**Borg Timber Processing Facility Expansion, Oberon-Mod-4 (SSD-7016-Mod-4)
Request for additional information**

I refer to the modification application for the Borg Timber Processing Facility Expansion at 126 Lowes Mount Road, Oberon (SSD-7016-Mod-4). We require the following additional information to complete our assessment of the modification:

DRAWING
PROPOSED MECHANICAL WORKSHOP ELEVATIONS & SECTIONS

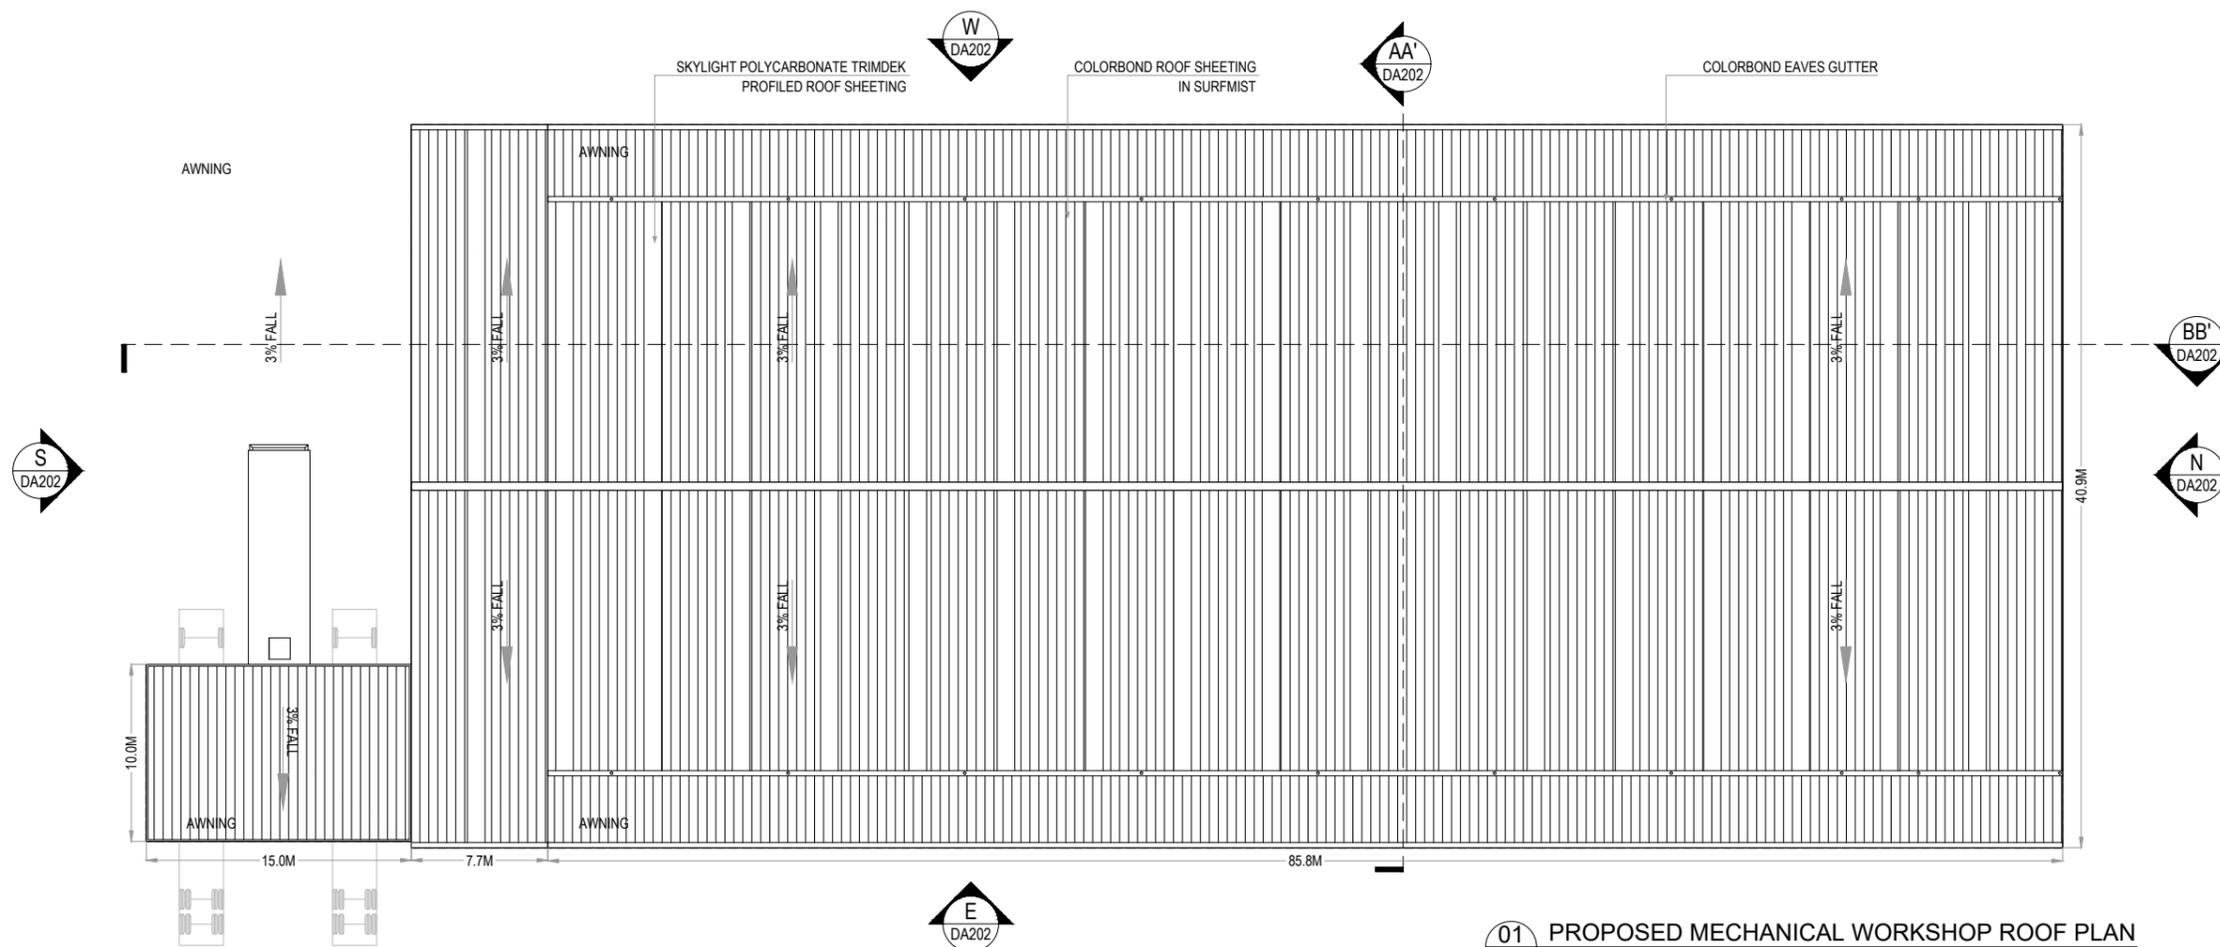
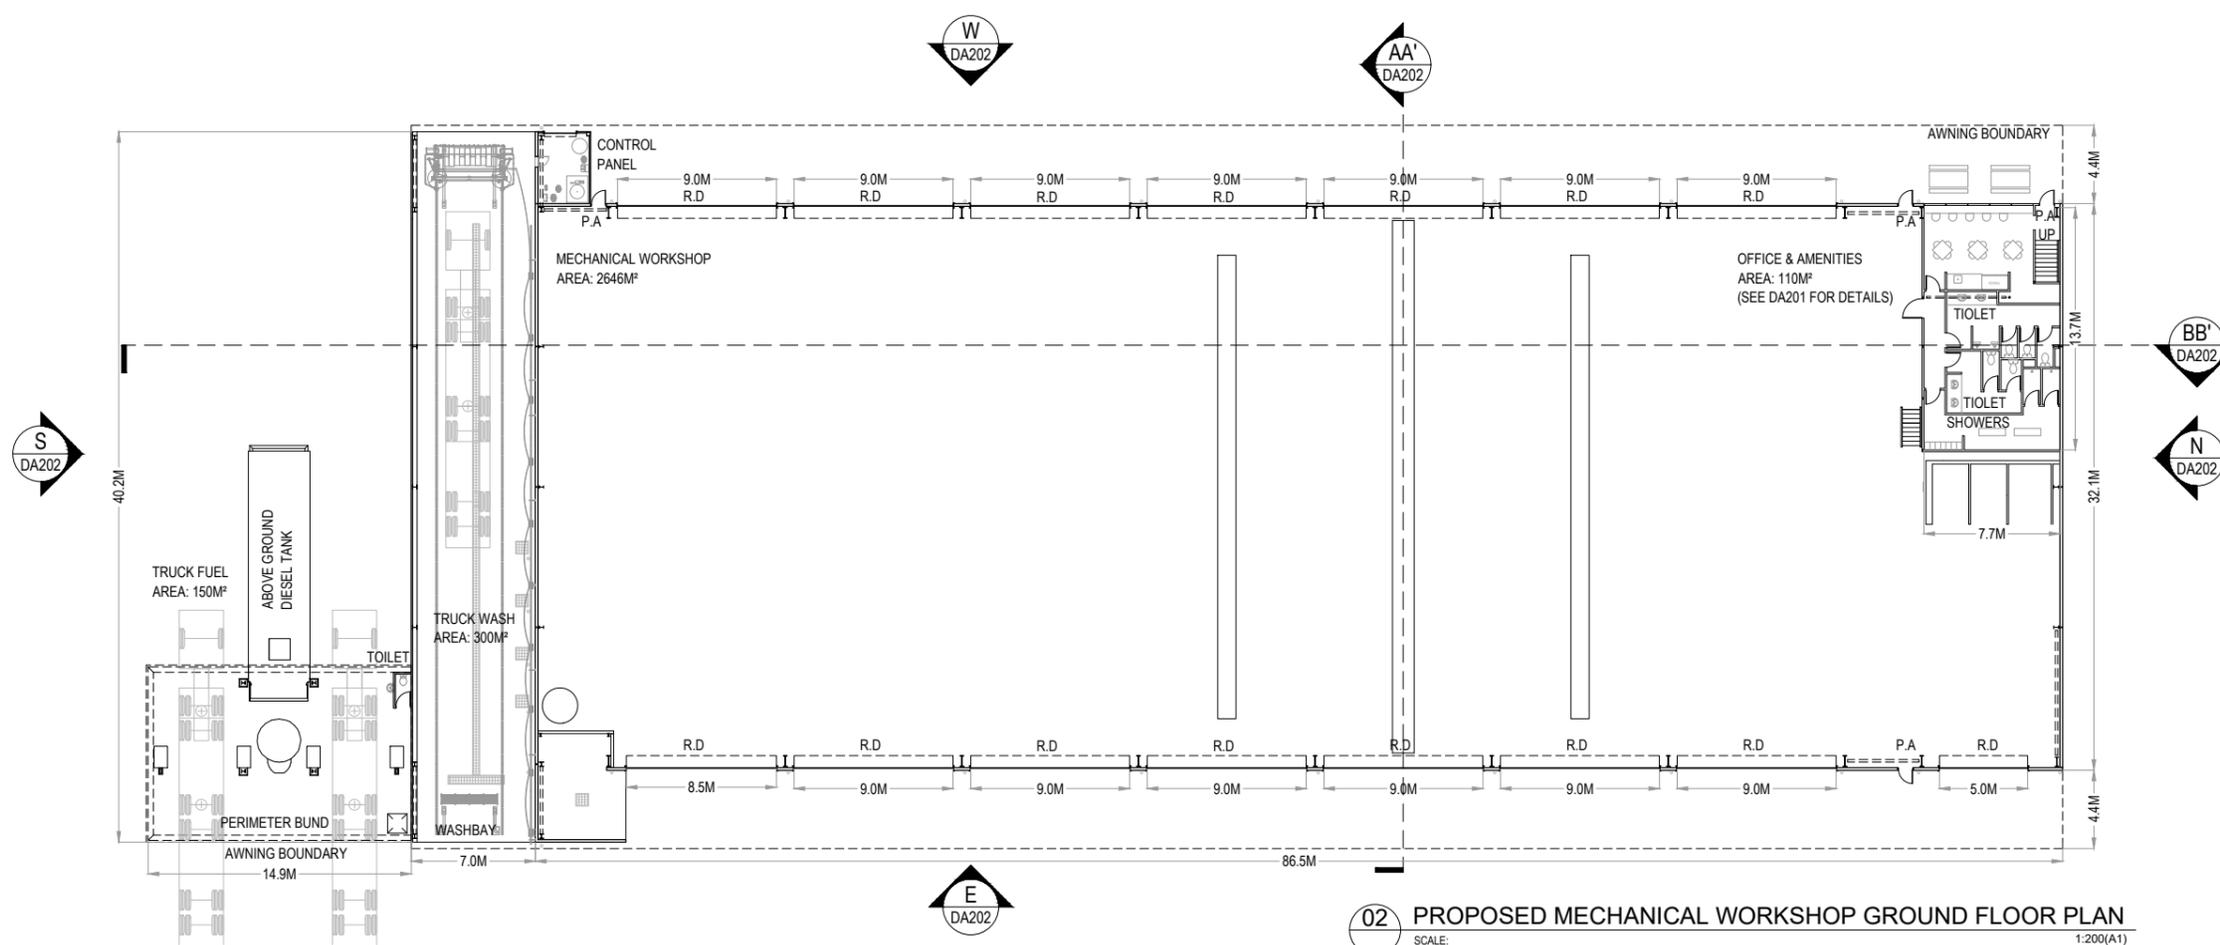
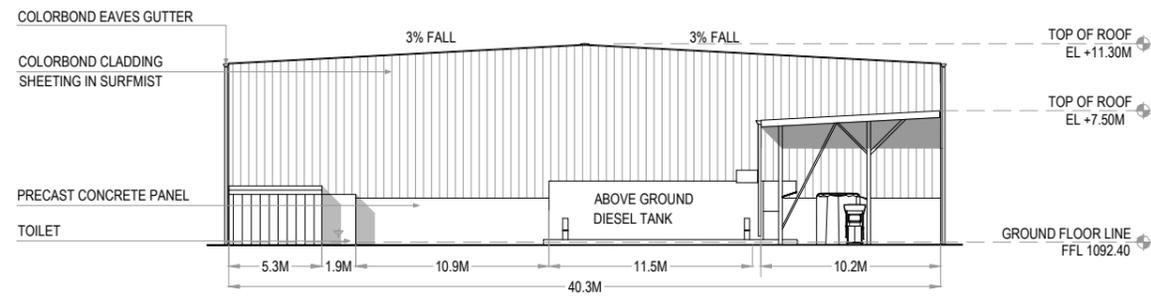
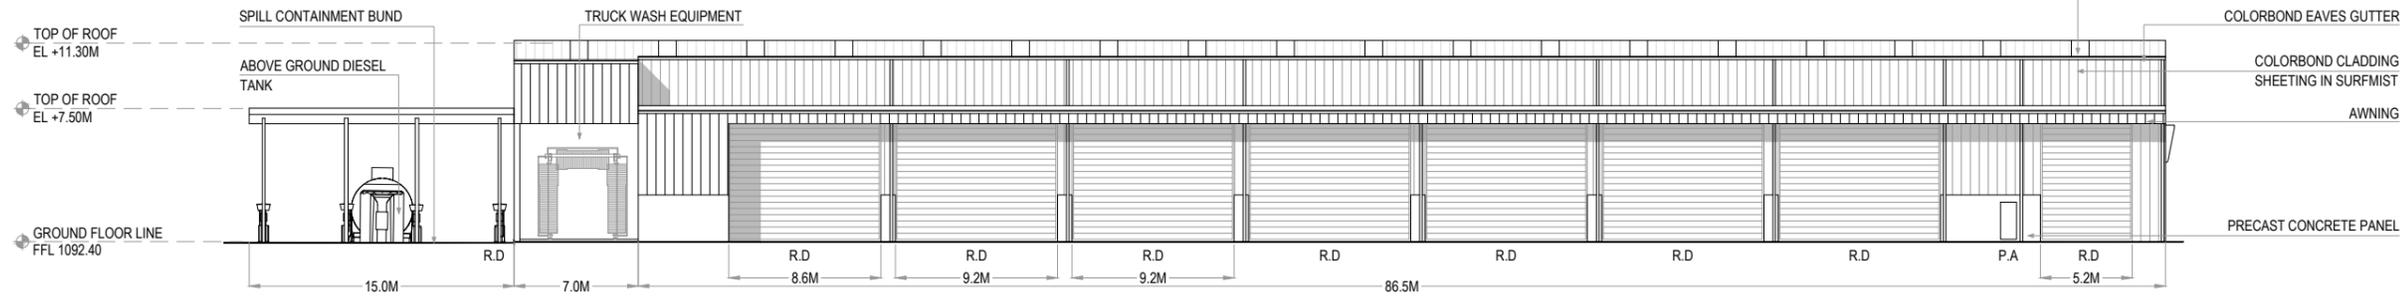
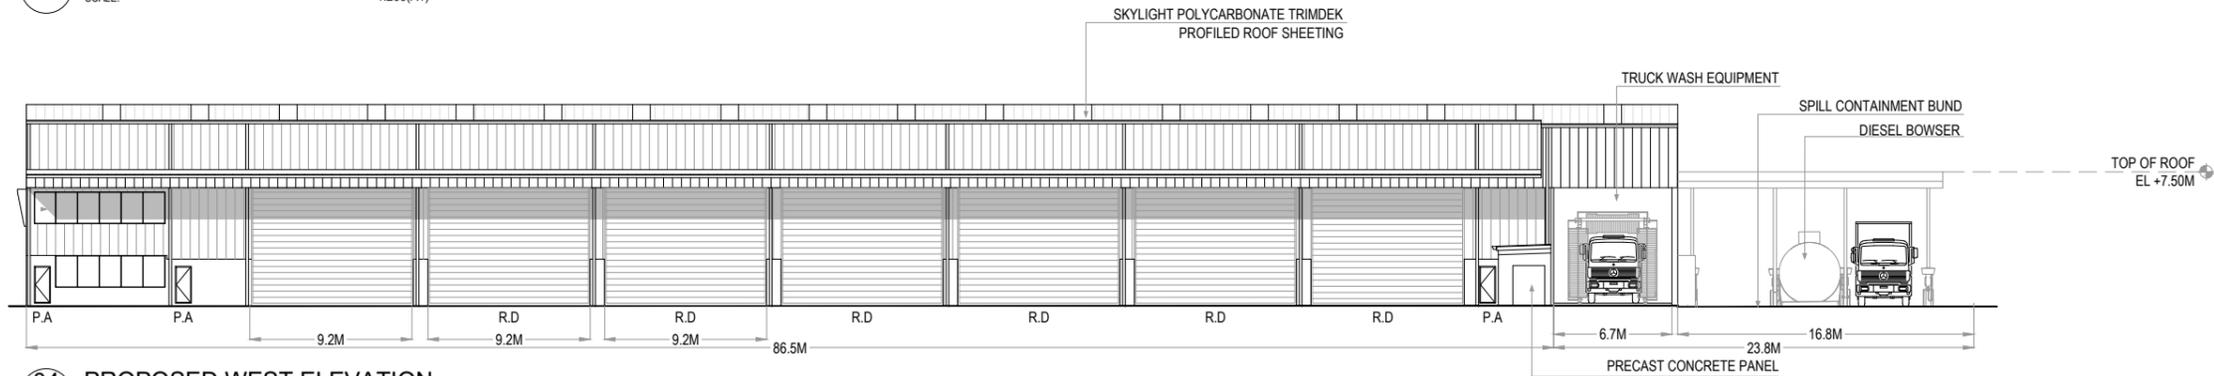
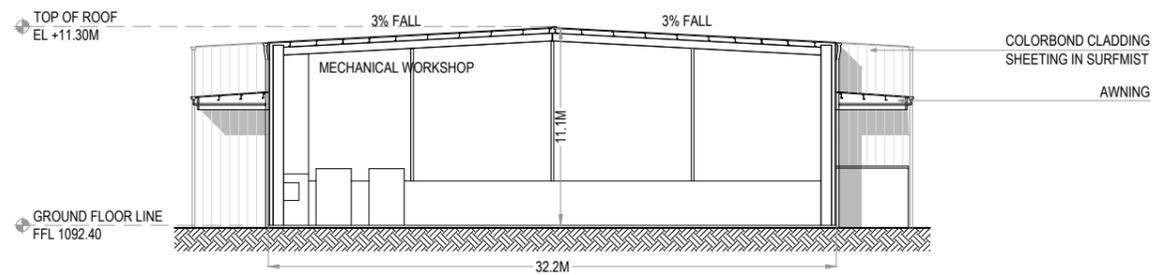
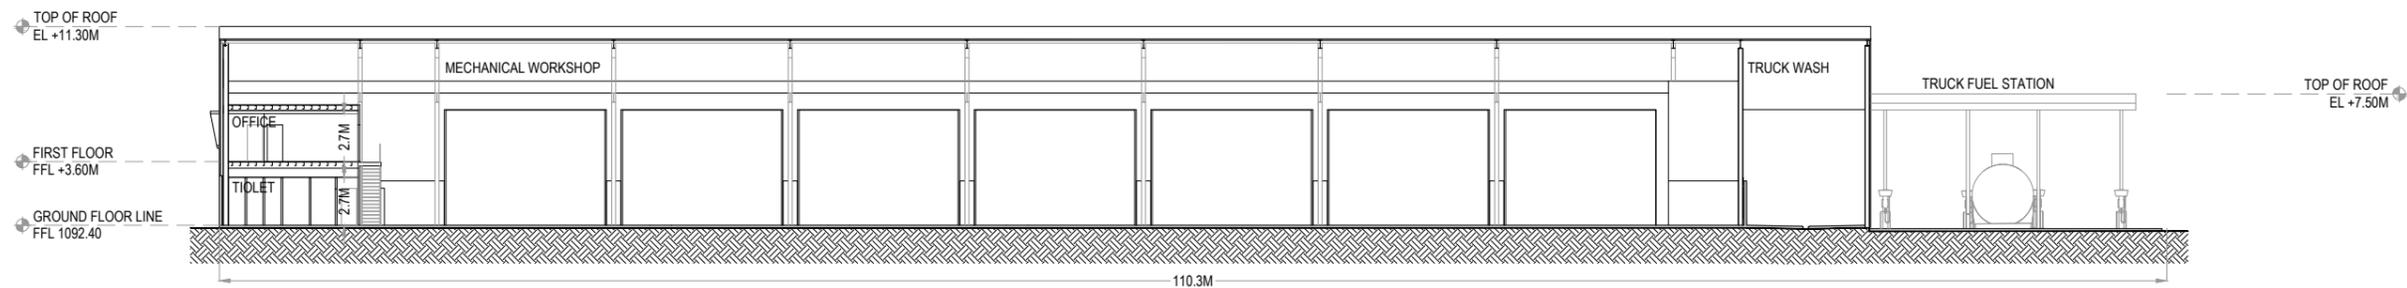
- Confirm the proposed construction materials and the dimensions of the proposed mechanic workshop (including height, width and length).
- Two reclamation methods are described in the Statement of Environmental Effects (SEE) – i) use of granular fill or ii) groundwater extraction bores. Provide additional details on how these methods would be carried out and the duration of the reclamation works. Describe the contingency measures that would be implemented if full reclamation of the Spring Fed Dam is unable to be achieved. What ongoing monitoring of the dam would be undertaken?
- Confirm whether a new scrubber is to be installed at the new discharge point and the height of the new stack.
- Is the MDL MDF plant currently operational or dormant?
- What is the timing and staging of the construction works?
